Subject: 3782 - 2021/93237 land off, Knowl Grove, Mirfield, WF14 9RF

I hope you are well. I am writing to you in response to the attached letter from the Consultation Response from KC, Lead Local Flood Authority. Please see attached updated Proposed Site Plan and updated Drainage Report as per comments. Please see a breakdown responses below:

Proposed drainage layout plan

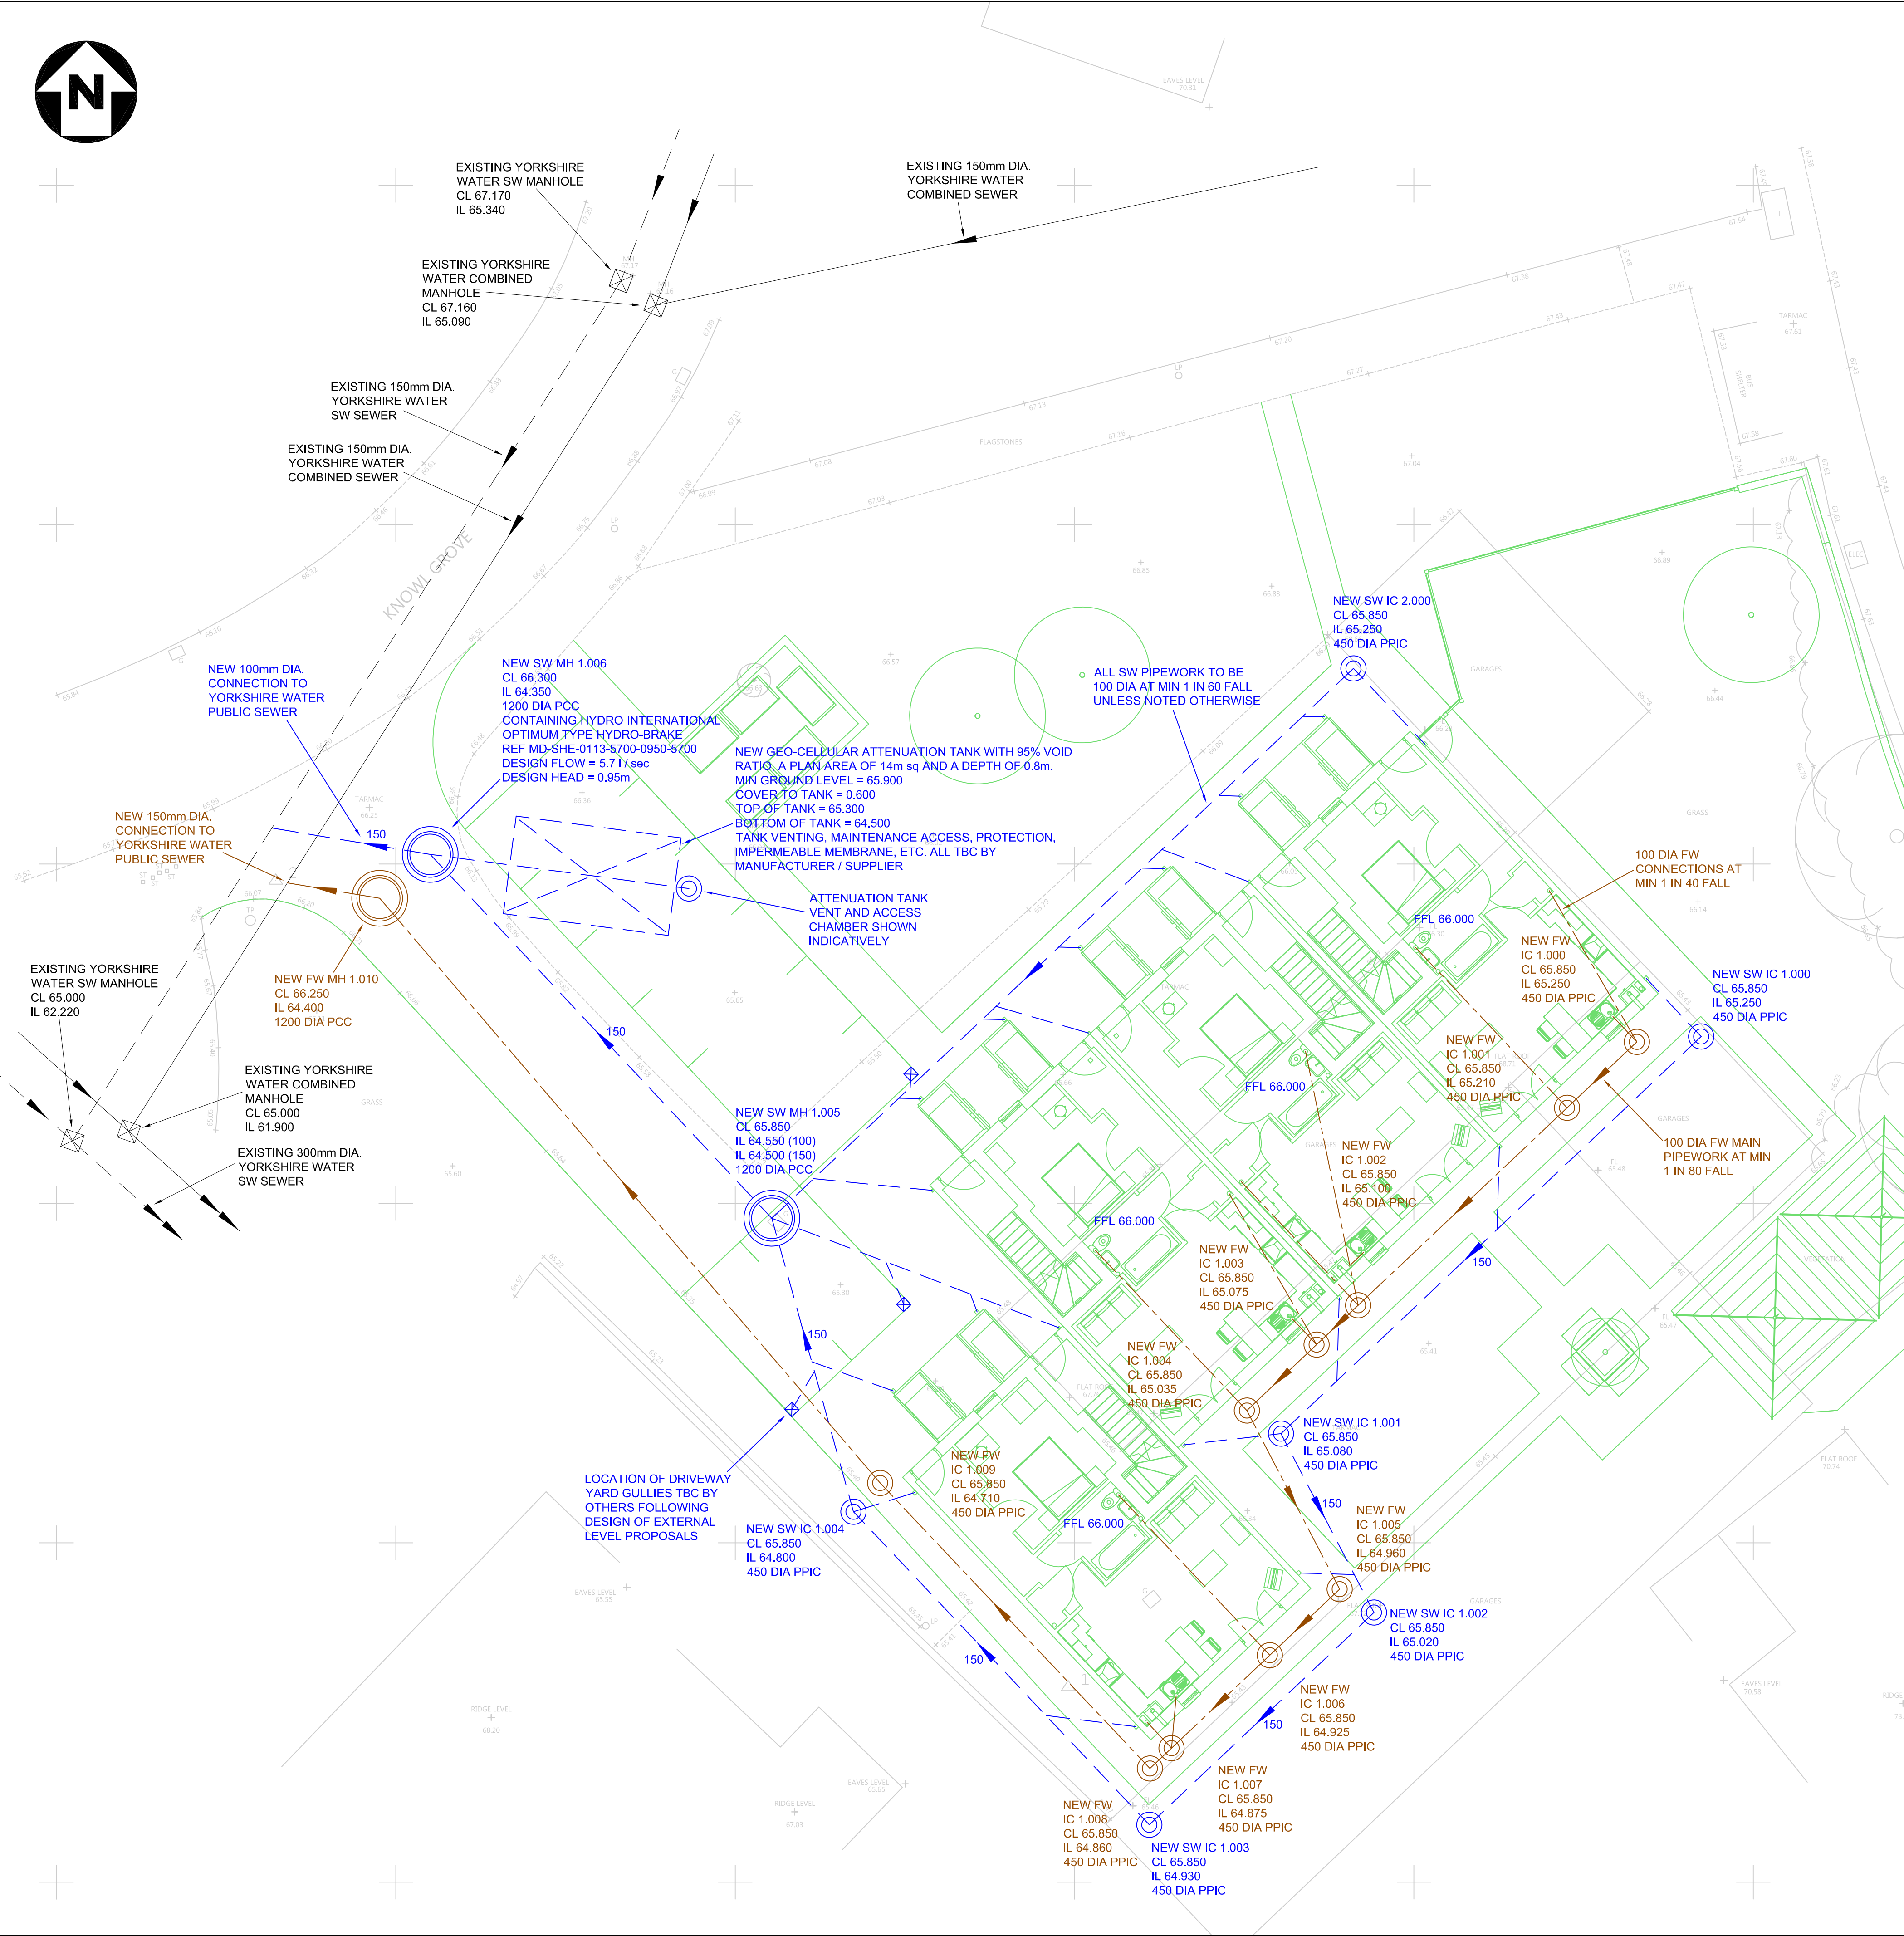
The Drainage Strategy section of the drainage drawing states that there are no watercourses on site or in proximity to the site. This is incorrect – as stated before in this response, and as shown in drawing Site Plan as Proposed, a culverted watercourse is crossing the site. The applicant should carry out a condition survey of this watercourse to determine whether it would be a feasible discharge point. [The “assumed” drain has been removed from the proposed site plan.](#)

Location of the proposed attenuation tank appears to be within the proposed 6m easement for the culvert crossing the site. Therefore, the proposed tank should be relocated. [The “assumed” drain has been removed from the proposed site plan.](#)

Pipe details, including numbers corresponding to the MicroDrainage outputs, should be shown in the drainage drawing to allow for cross checking. [Pipe reference numbers are confirmed by their upstream manhole references.](#)

The proposed attenuation tank is an offline structure, and according to the drainage drawing, the inlet/outlet pipe is proposed to be 100mm diameter in size. This pipe should be an oversized pipe, to limit the possibility of blockage and ensure the attenuation remains operational. [The Drainage Design Information document has been updated to address this comment.](#)
